EPC STORMWATER REVIEW COMMENTS
IN ORANGE BOXES WITH BLACK TEXT

~~Master Development Drainage Plan and
Final Drainage Report~~

Peerless Farms
16975 Falcon Hwy
Peyton, CO 80831

PCD File No. SF242

K:\COS_LA\196114000 - Peerless Farms\CADD\Exhibits\Existing Drainage Map.dwg

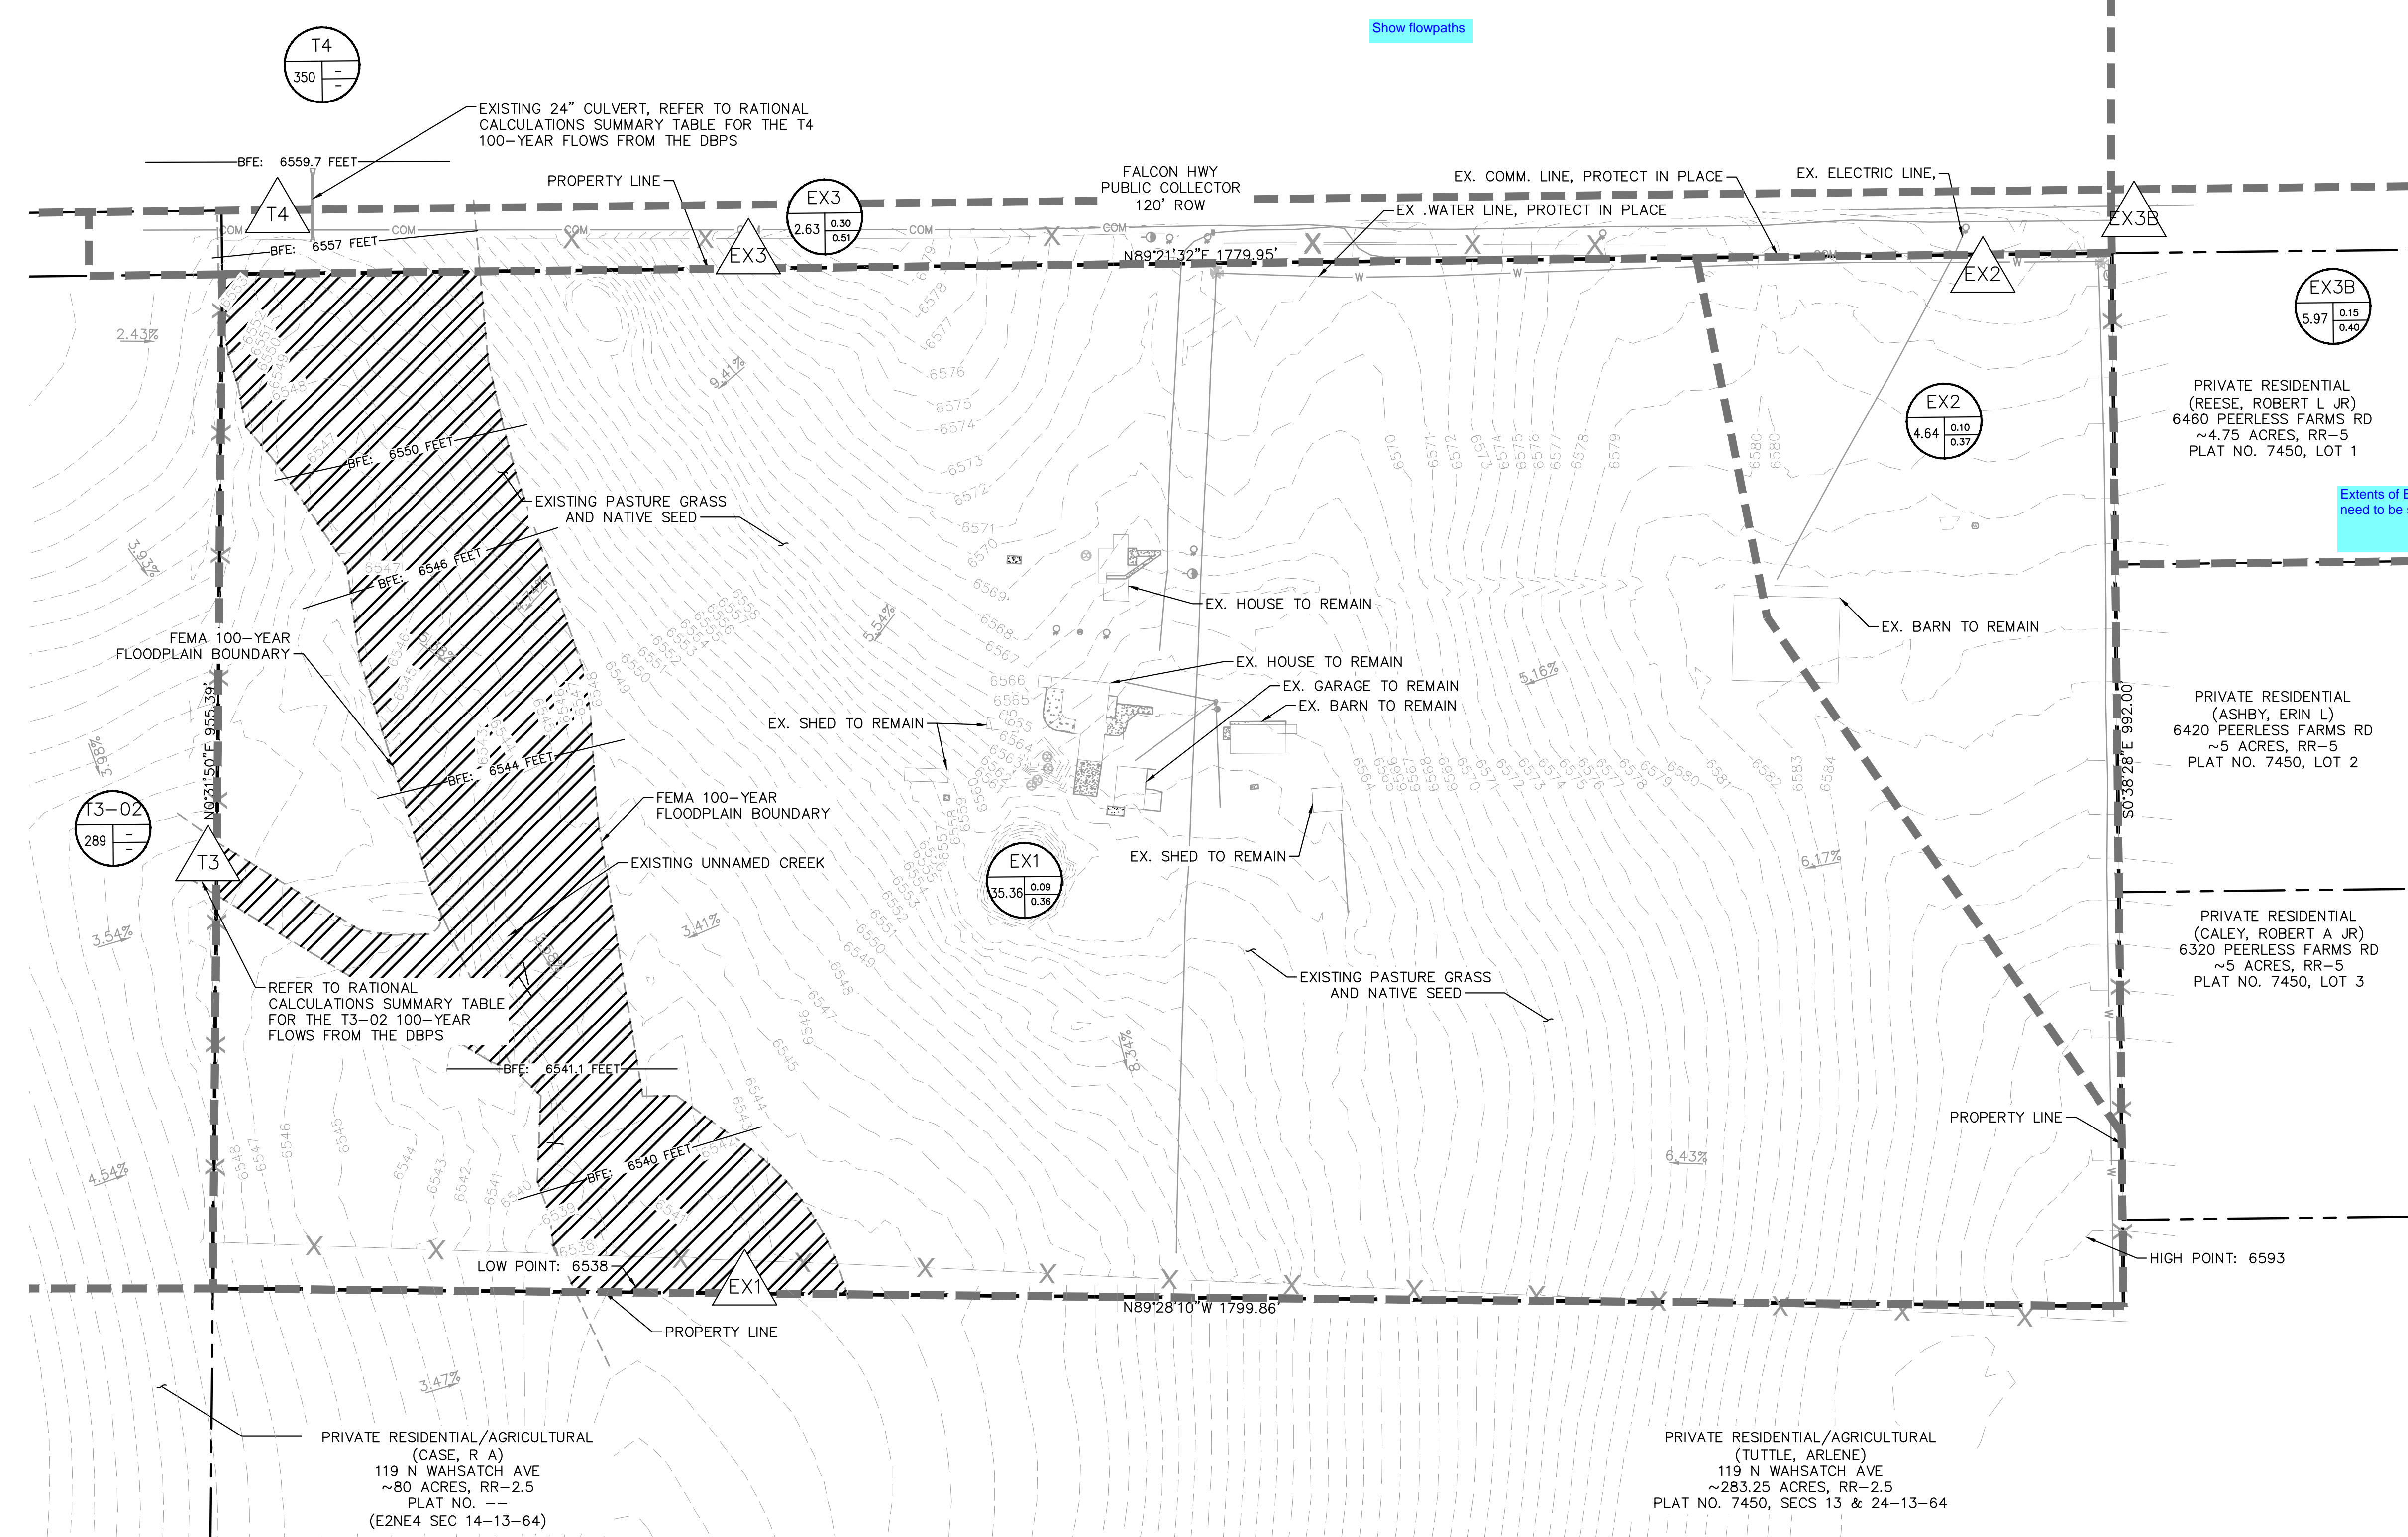
Unresolved: DP EX1 is total of all basins. Please provide separate line for this DP

Unresolved: DP EX3 is combined flows of Basins EX3, EX3B & EX2. Please provide separate line for DP

As discussed in a call with county staff, no additional rows or sub-basins are required. Notes just need to be added in the "Remarks" Section which explains which Sub-Basins contribute to the cumulative flows. This information is redundant because it is already found within the FDR narrative, but we have added it at the request of the county.

As discussed in a call with county staff, no additional rows or sub-basins are required. Notes just need to be added in the "Remarks" Section which explains which Sub-Basins contribute to the cumulative flows. This information is redundant because it is already found within the FDR narrative, but we have added it at the request of the county.

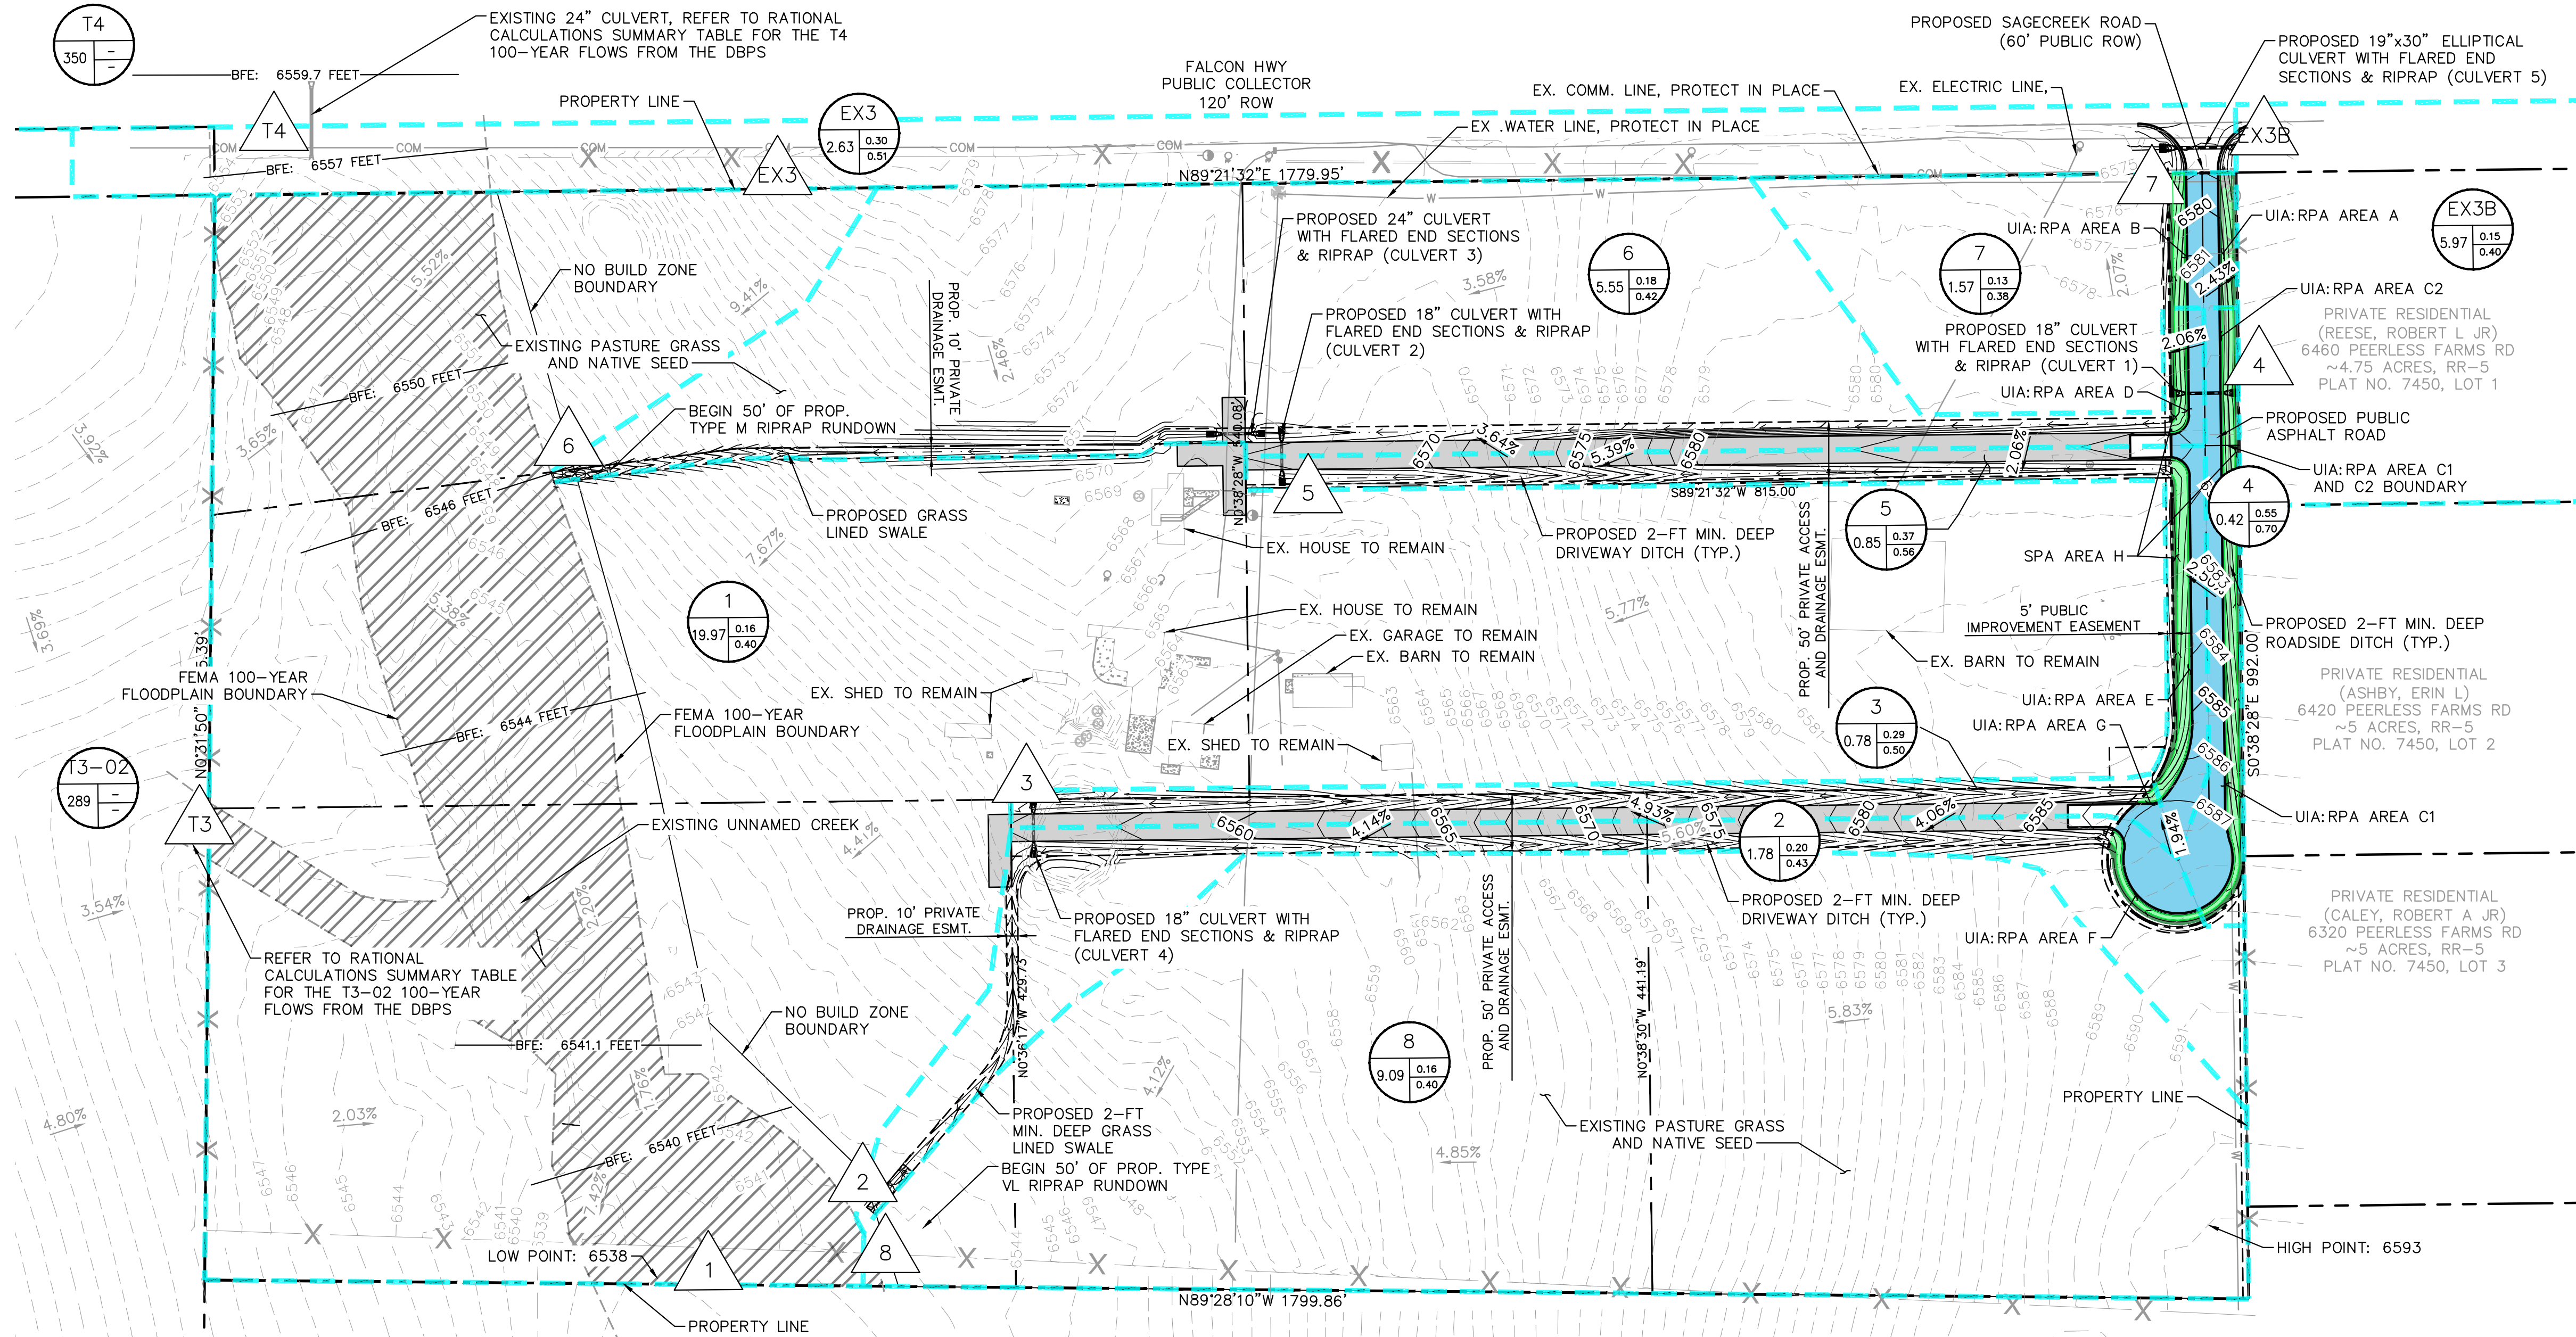
Unresolved from Submittal 1: The last section of the public road does not flow directly to the unnamed drainageway but rather flow to a low spot along Falcon Highway. Discuss any increase in flows/suitable outfall for that basin because it has a different discharge location. It is understood that the roadside ditch will flow, but when discussing the potential downstream impacts both discharge points, the unnamed tributary and the roadside ditch, need to be discussed for the suitability of the outfalls.

We discussed this with county staff and have added two sentences that discuss the path of the flows that flow off-site and then west to the unnamed channel. We aren't changing the discharge location. The historical path of stormwater is being maintained. We are actually improving things here by allowing less stormwater to discharge off-site. Based on our follow-up call with the county this comment should be addressed. Thank you!
